Council Reference: DA10/0642 LN18752
Your Reference: 09_0016

Major Project Application MP09_0016 - Mixed Use Tourist and Residential Development at Lots 1 - 3 Section 1 DP 29748; Lot 4 Section 1 DP 31209, No. 2 - 6 Tweed Coast Road and No. 10 Cypress Crescent Cabarita Beach (DA10/0642)

SUBMISSION

Title
LANDSCAPE
PLANTING
PLAN - LV 2 & 3

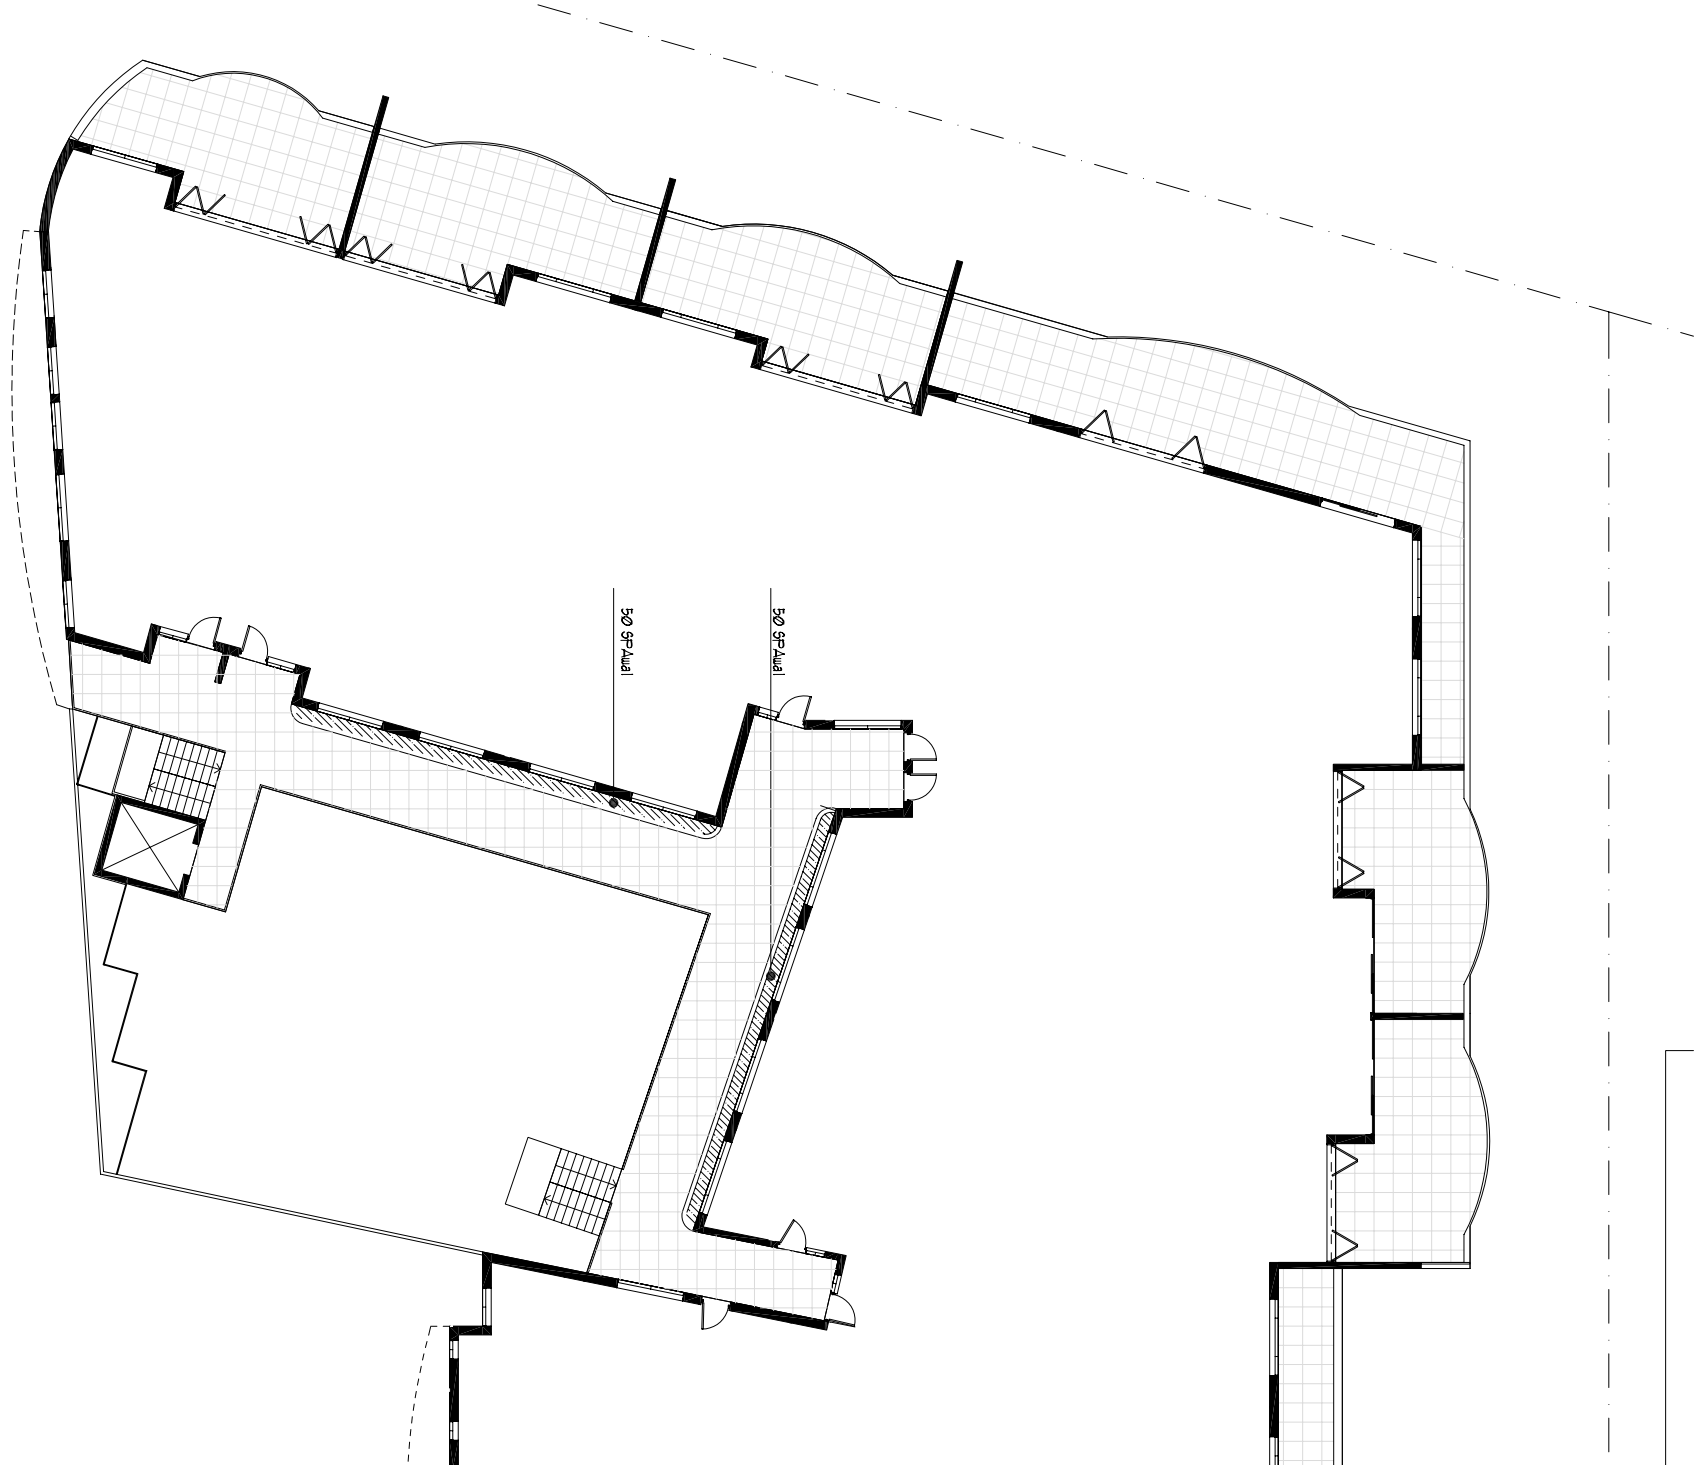
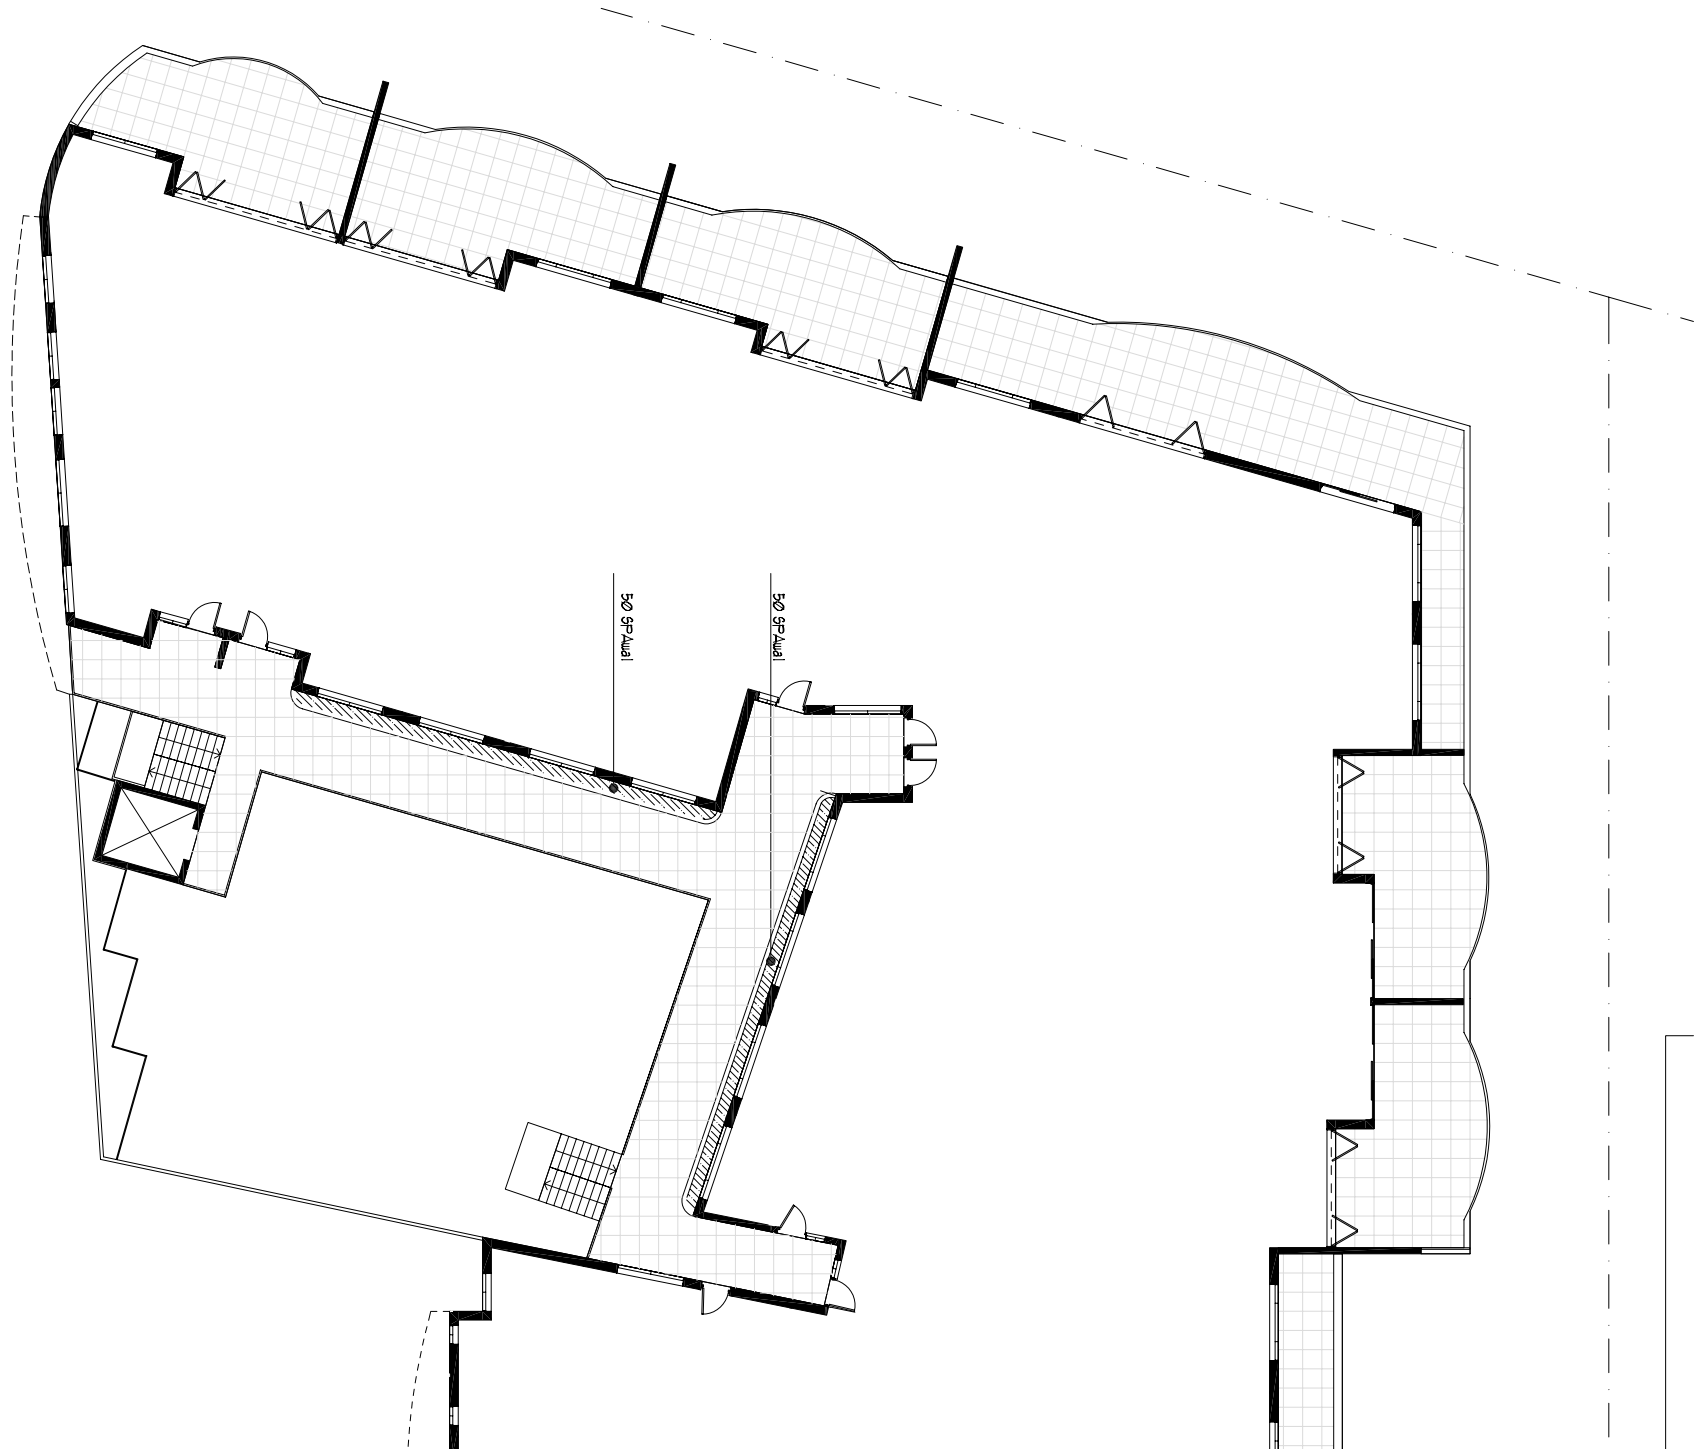
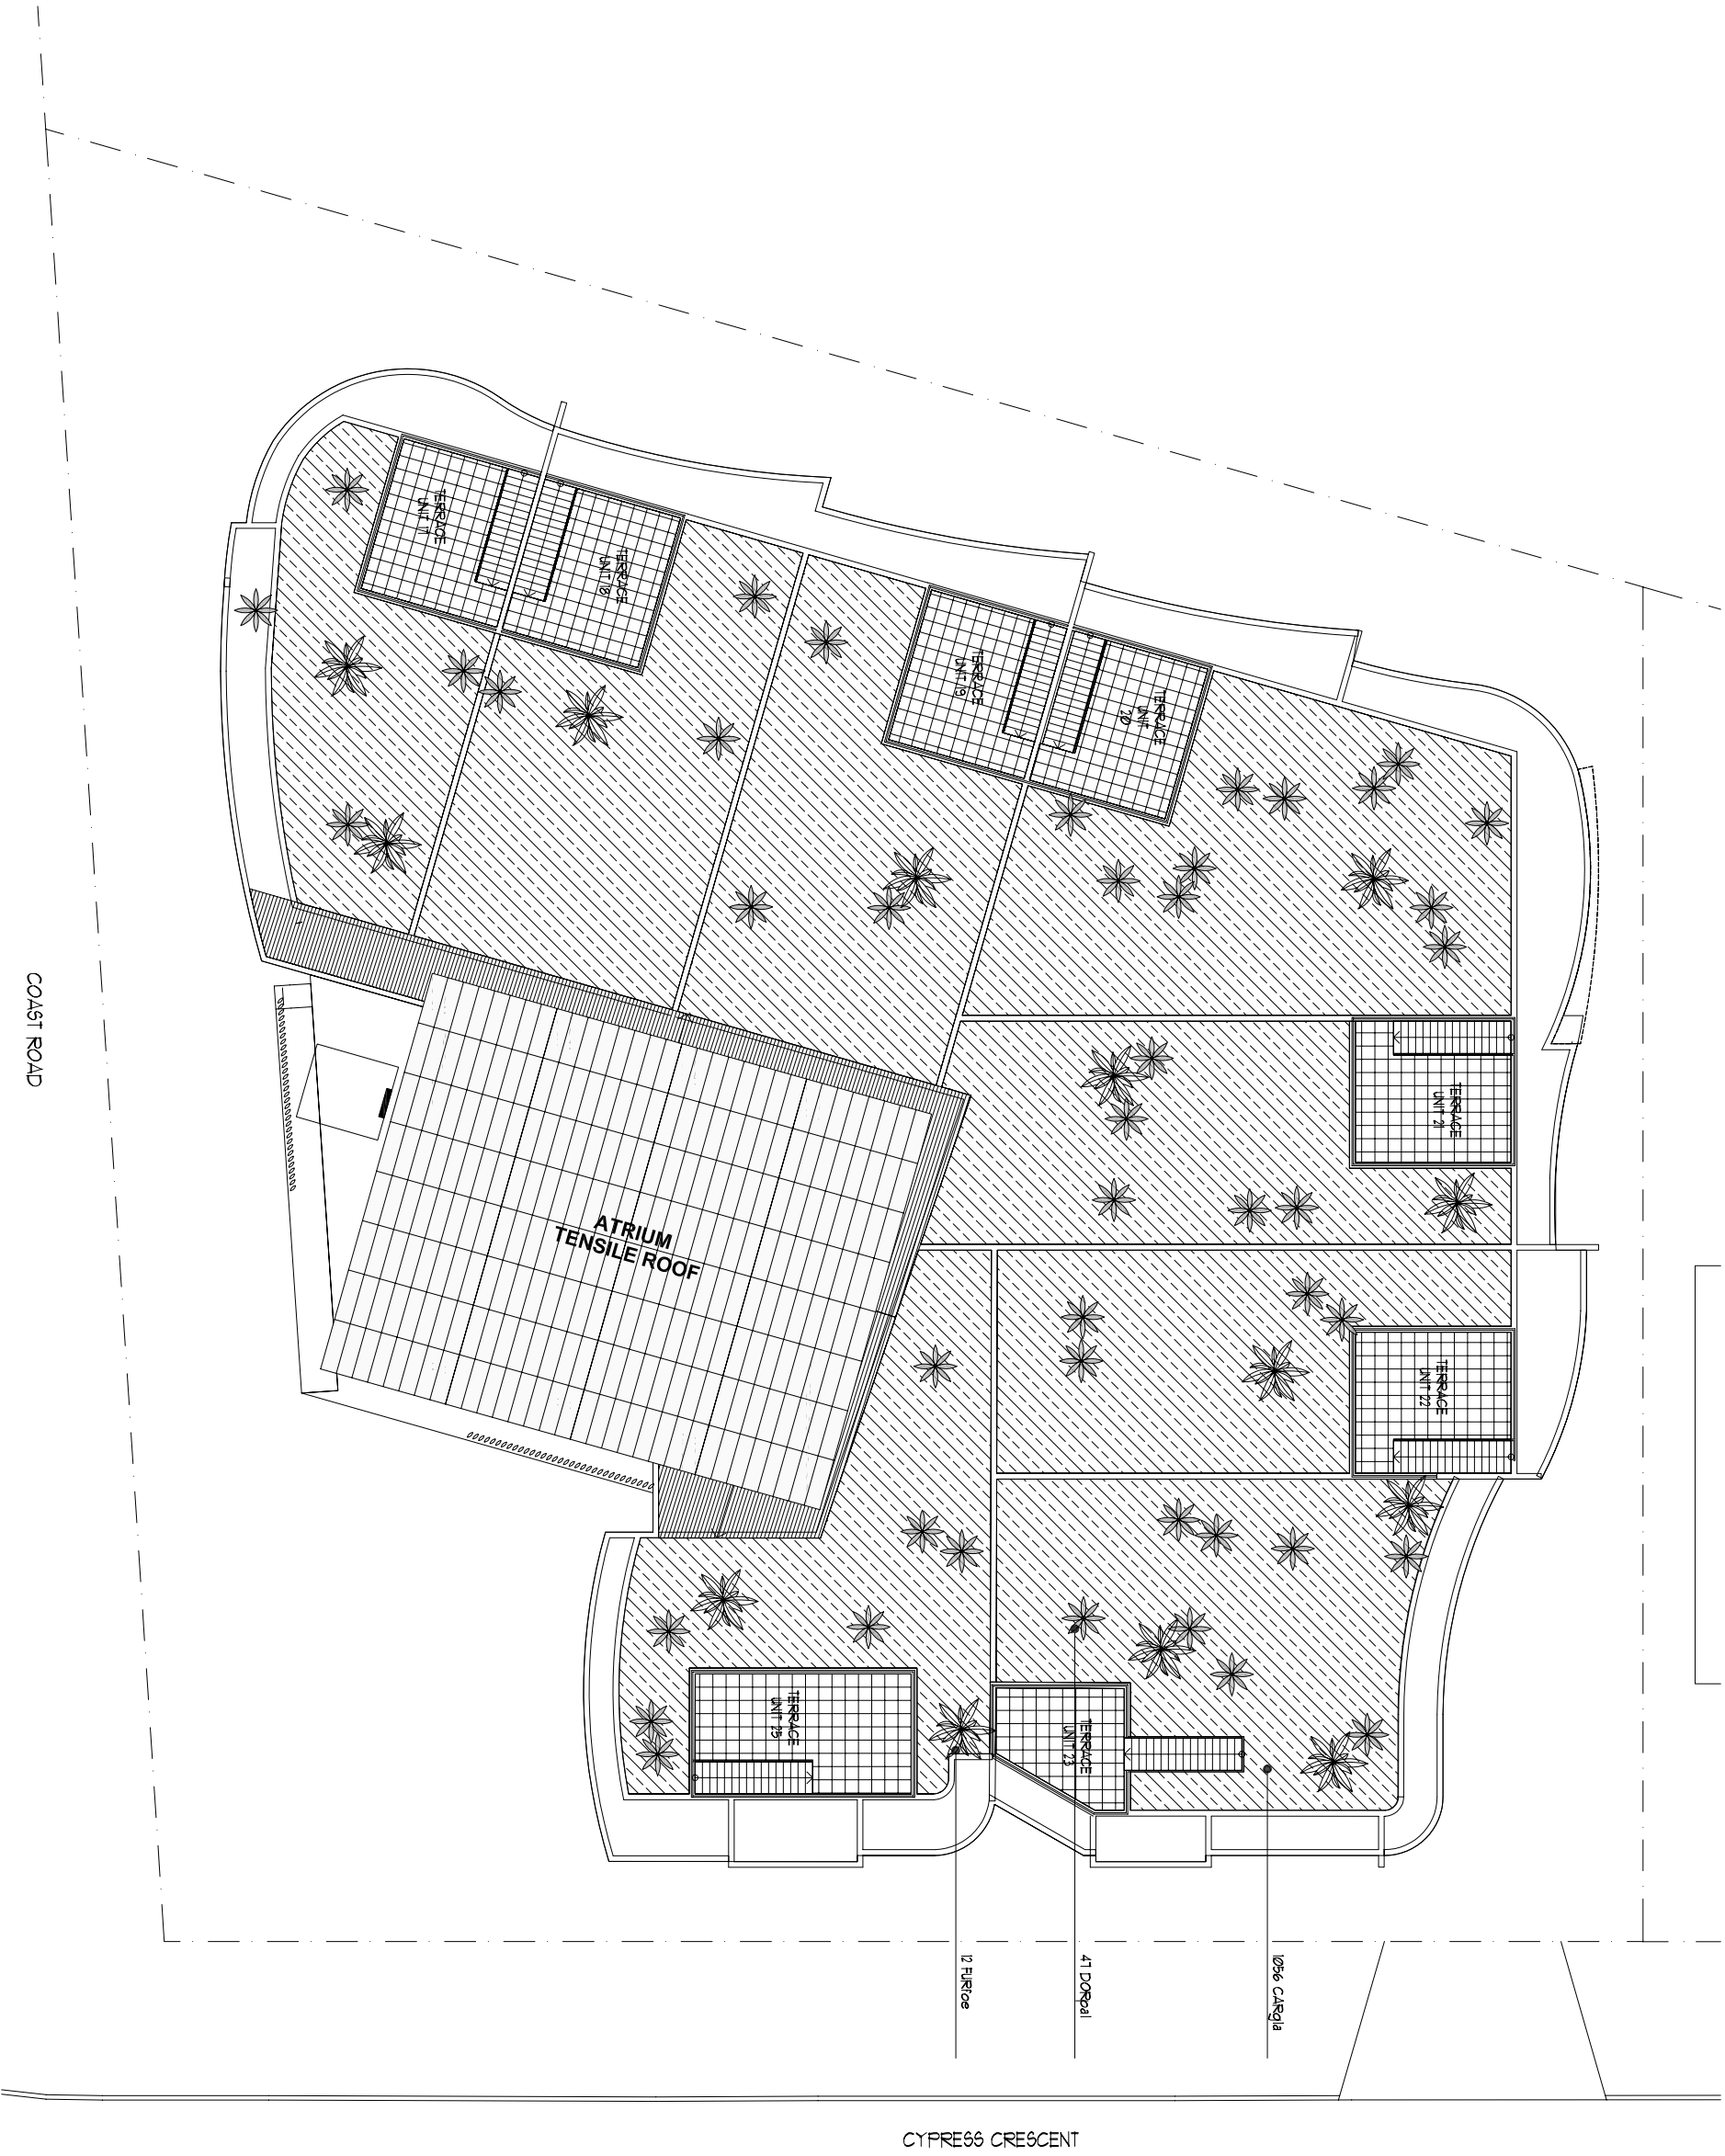
Plan No LH-DD-02 (C) Rev C (Landscape Hardworks Plan Levels 2 & 3) (as amended in red) prepared by Master Planning Landscape Design and dated 2 June 2010
